From: Brian Banister [REDACTED]
Sent: 21 September 2025 10:15
To: Planning.Responses
Subject: Arun Conservation Area Advisory Panel comments on applications

The **Arun Conservation Area Advisory Panel** wish the following comments to be taken into account in the determination of the applications:

BR/107/25 - Ancient Mariner Hotel, 59 West Street, Bognor Regis

Proposed Front Elevation 1:100

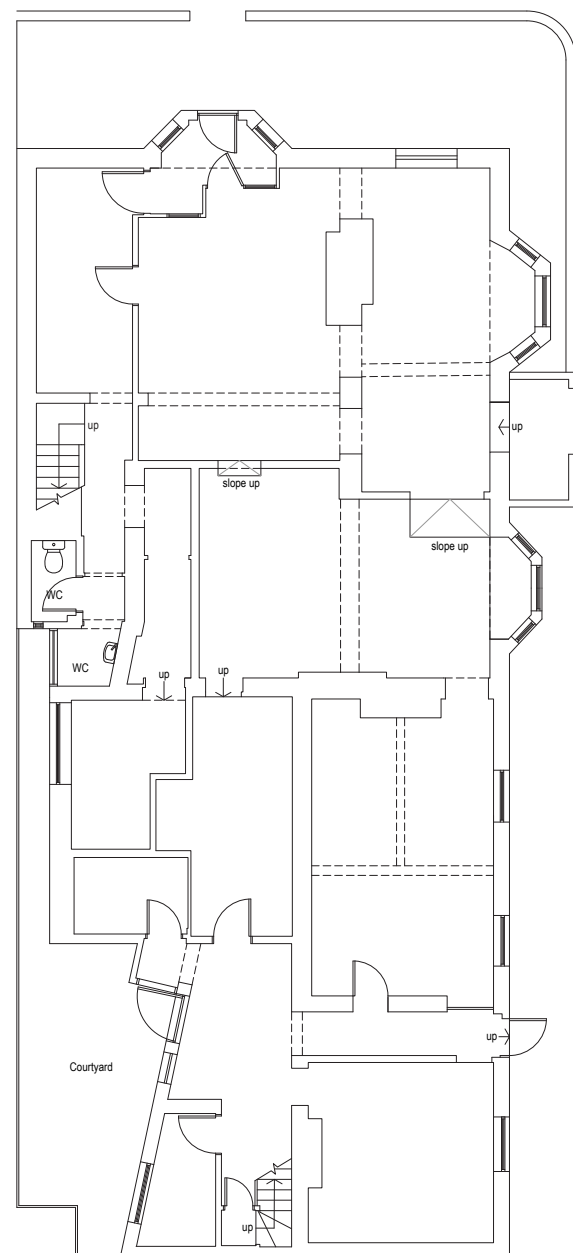
The Panel welcome the proposed refurbishment of the building and its intended uses.. However, it was considered that the existing entrance from West Street would be better retained rather than alter the prominent front bay window which is such an important feature of the building.

It was also considered important to paint all the new joinery one colour (white preferred) rather than repeat the existing mishmash of brown and white.

Given the designated and non-designated heritage asset context it was considered important that precise details of the new windows and doors should be required to ensure that they are of traditional design, materials operating mechanism, etc. It will also be important that the depth of the reveals is the same as existing.
